Planning Inspectorate

Keadby Next Generation Power Station – EN0110001

Section 51 advice regarding draft application documents

Issued on 16 July 2025

Works Plans
Work No. 4B
(Plan 1 of 1)

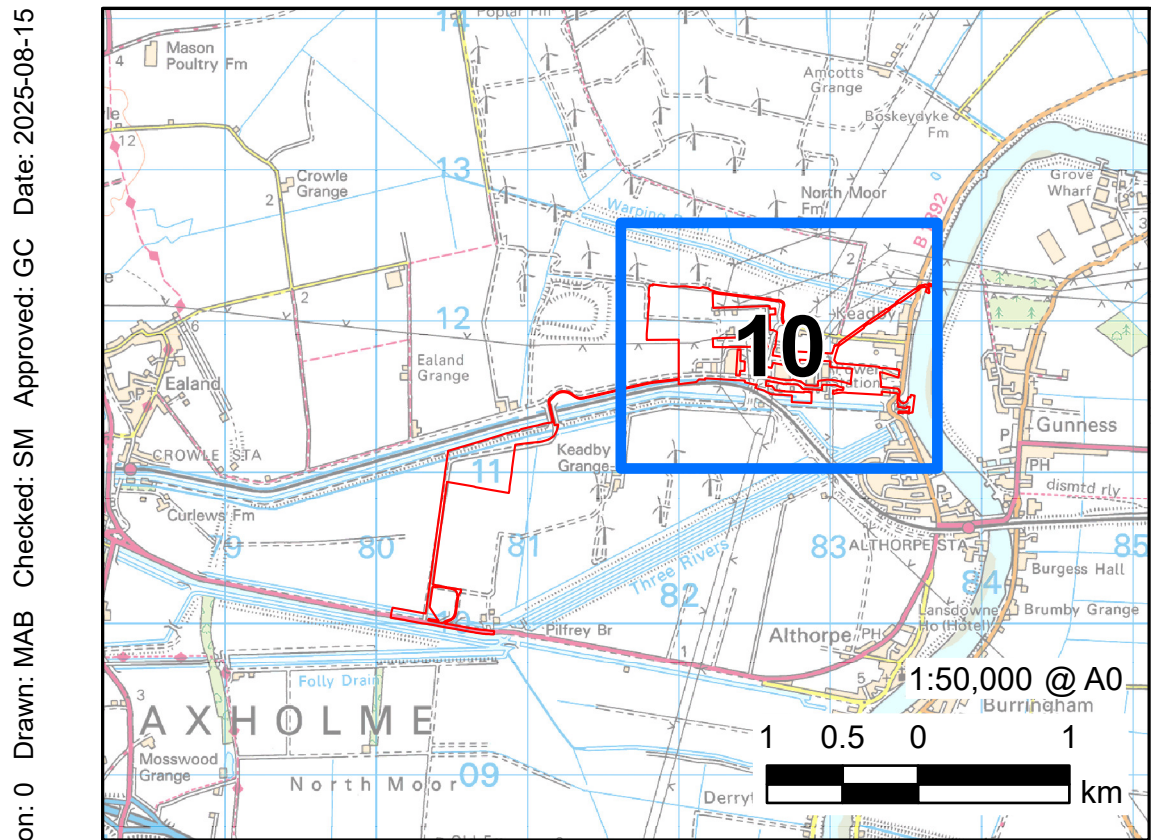
9.	Works Plans	Plans don't state whether they are A0/A1 size.
10.	Works Plans Sheet 9 (Work No. 4B)	The orange pattern used to identify the plot does not match the pattern used in the legend.
